KITTITAS COUNTY DEPARTMENT OF PUBLIC WORKS

DATE: March 07, 2019

RE: ACU-19-0001 Teanaway Cell Tower

SHEET NUMBER: A-1.2

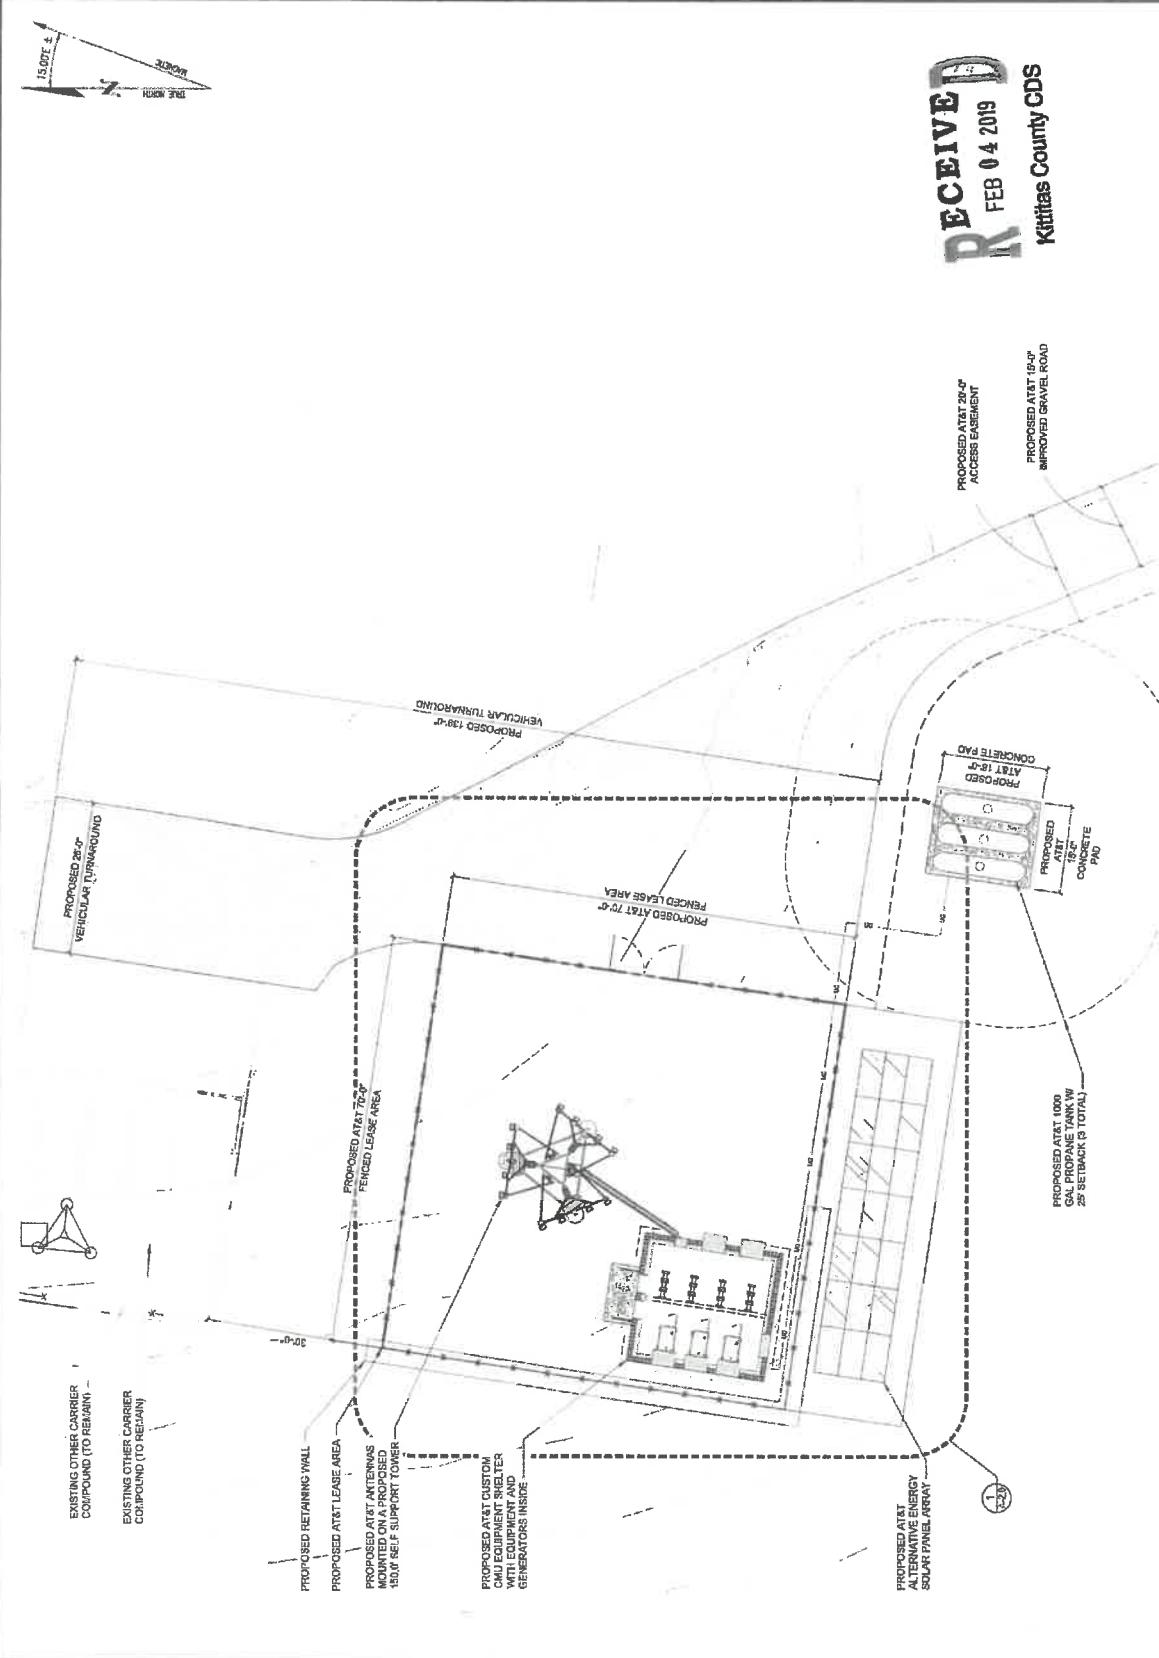
1. Access
The access roadway shall meet the current Kittitas County driveway standard. Greater than 150 feet in length requires a 16 foot all weather surface with two foot clear zones on each side.
2. Stormwater
The creation of greater than 5,000 square feet of new impervious area requires biofiltration swales along the perimeter edge of impervious surfaces allowing treatment and disposal of new impervious area.
3. Hazardous Slopes
The application suggests that potentially hazardous slopes are associated with the tower parcel. Improvement construction should avoid getting too close to steep slopes particularly where the infiltration of improved runoff is likely to occur.
